From: Lewis, Trevor <Trevor.Lewis@lancashire.gov.uk>
Sent: 04 August 2014 13:57
To: Colin Sharpe
Cc: planning; ENV LHS Customer Service
Subject: 3/2014/0583 Black Bull Rimington

Proposed Site Plan - 1:100

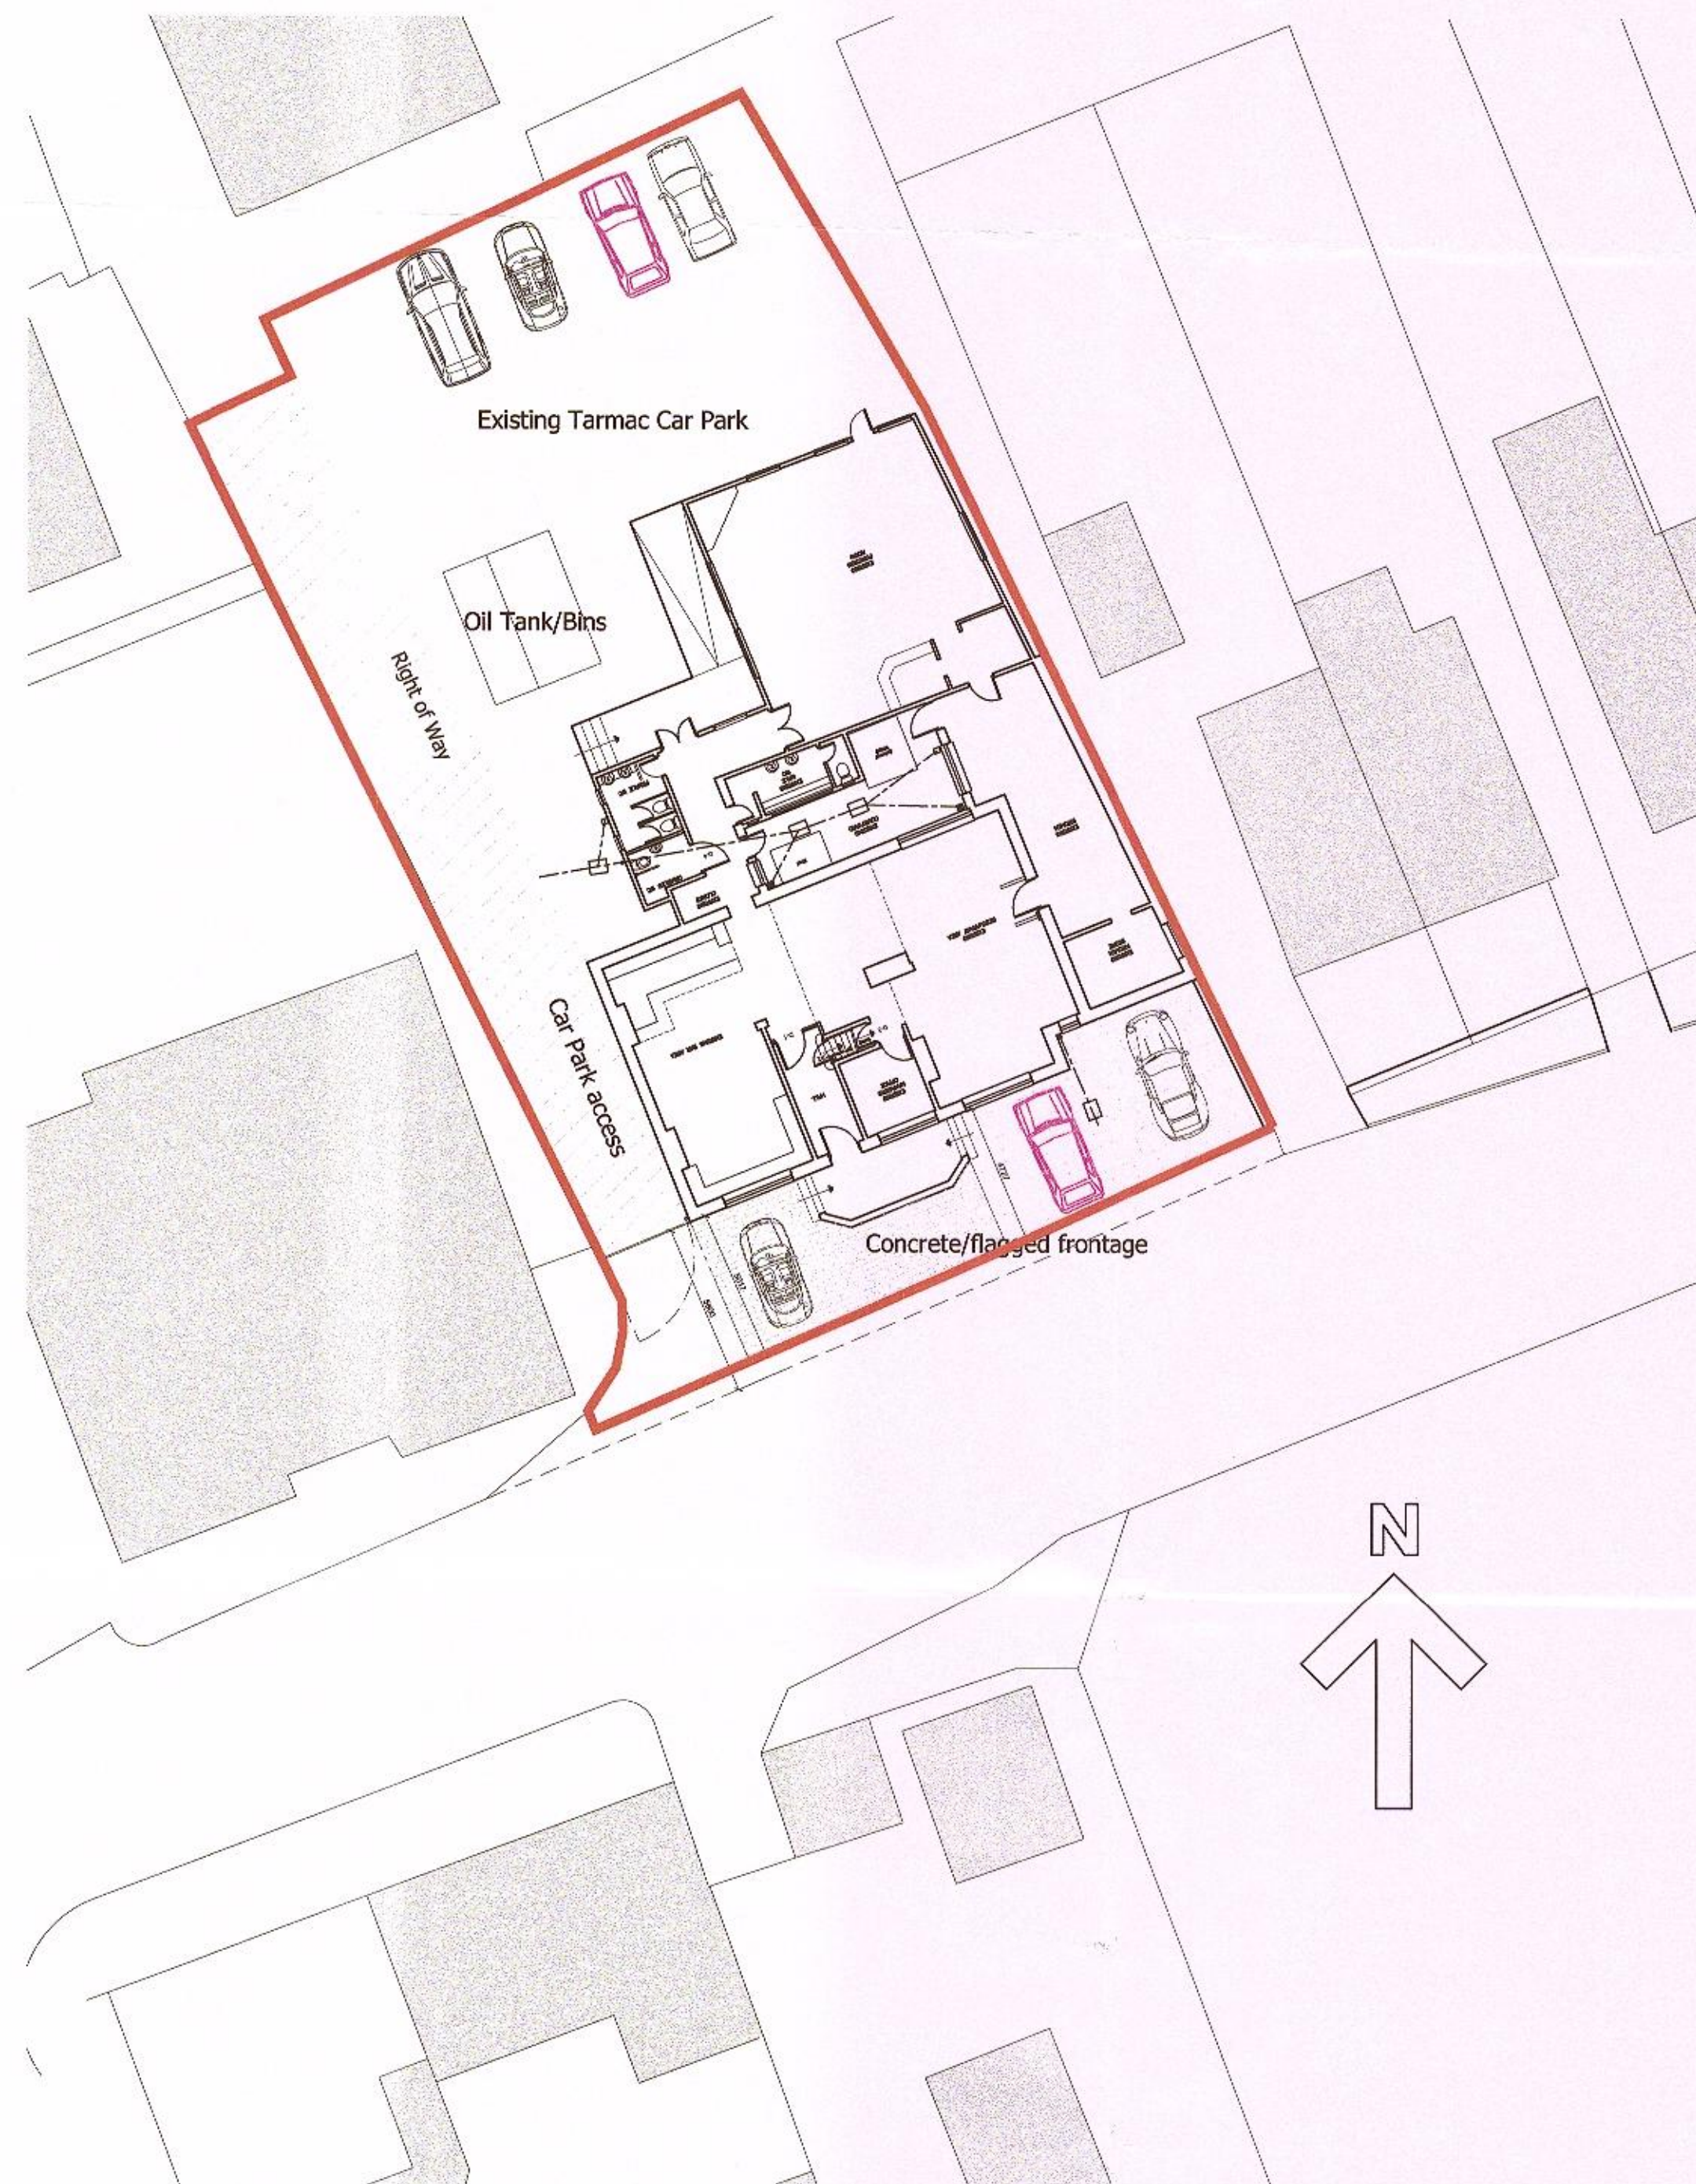
The 'existing retained gate' should open the other way – that is inward away from Rimington Lane.

The car park at the rear of the building should retain an area for vehicles to be able to turn around and drive onto Rimington Lane in forward gear.

The layout of the development shall include provisions to enable vehicles to enter and leave the highway in forward gear and the vehicular turning space shall be laid out and be available for use before the development is brought into use. Reason: Vehicles reversing to and from the highway are a hazard to other road users.

The car park shall be surfaced or paved in accordance with a scheme to be approved by the Local Planning Authority and the car parking spaces and manoeuvring areas marked out in accordance with the approved plan, before the use of the premises hereby permitted becomes operative. Reason: To allow for the effective use of the parking areas.
